Town & Country Planning Act 1990 (as amended)
Town & Country Planning (Development Management Procedure) (England) Order 2015
Application for Planning Permission for Works or Extension to a Dwelling

Development Rear single storey extension and alterations to roof to facilitate loft enlargement including increase to ridge height
Amendments sought to plans as passed on application FG/217/18/HH

Location 3 Lamorna Gardens Ferring

BLOCK PLAN 1:500 @ A4.
27/11/18.
DRAWING No. DS/LAMORNA/07.

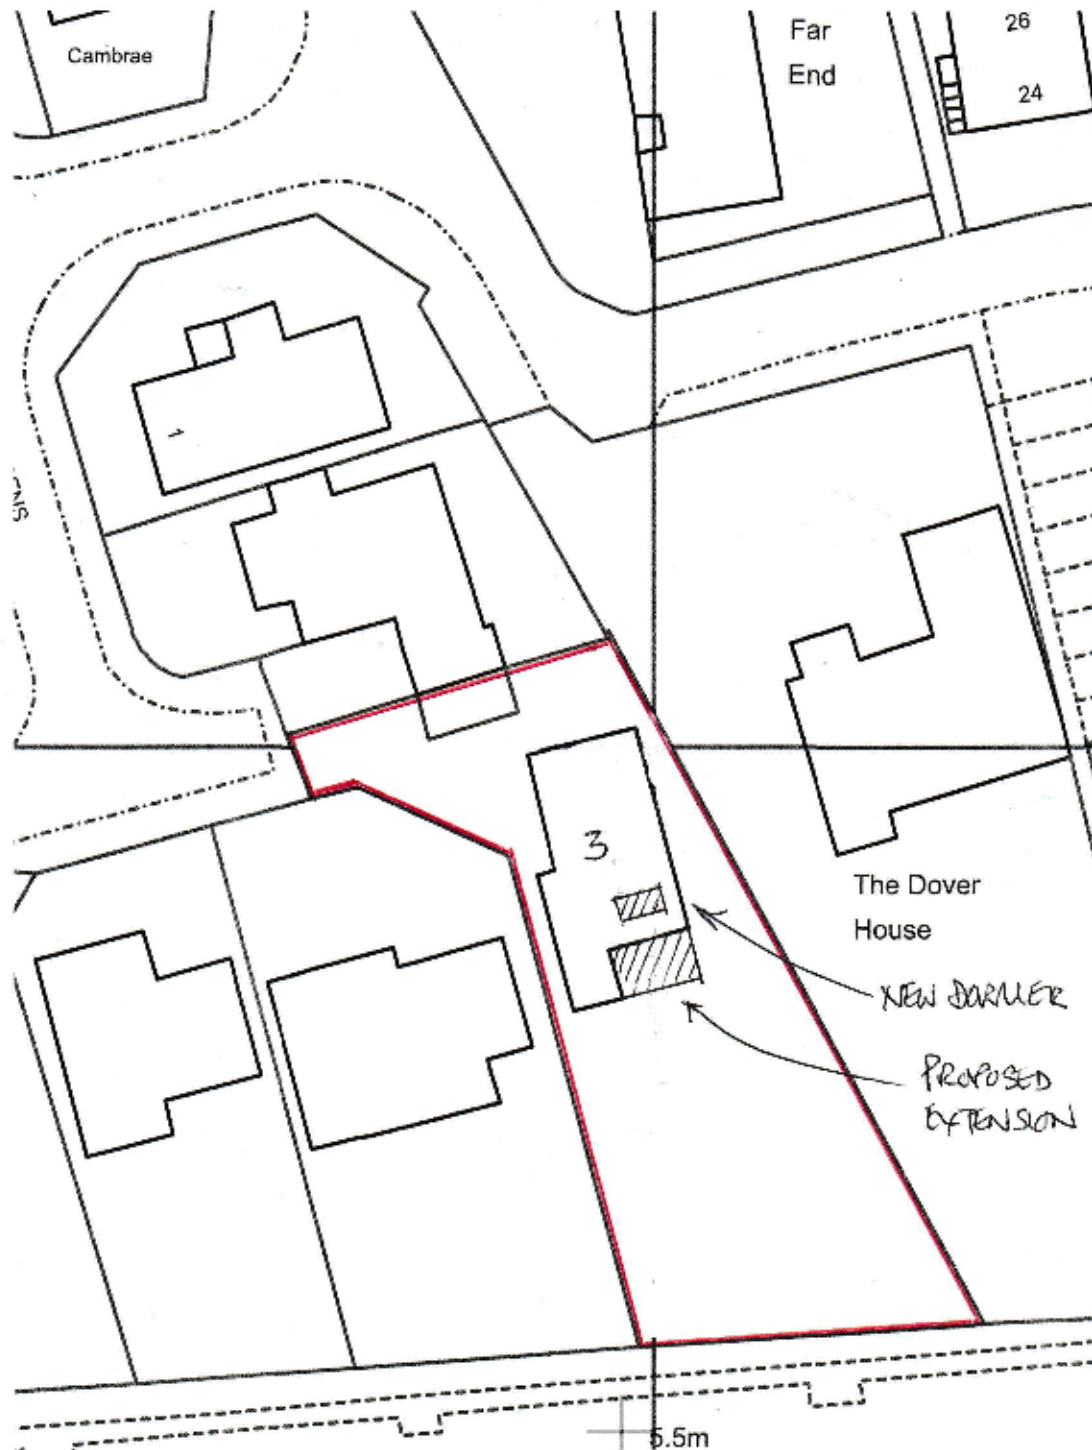
You are required to have dimensions on your block plan from the proposed extensions to all site boundaries.
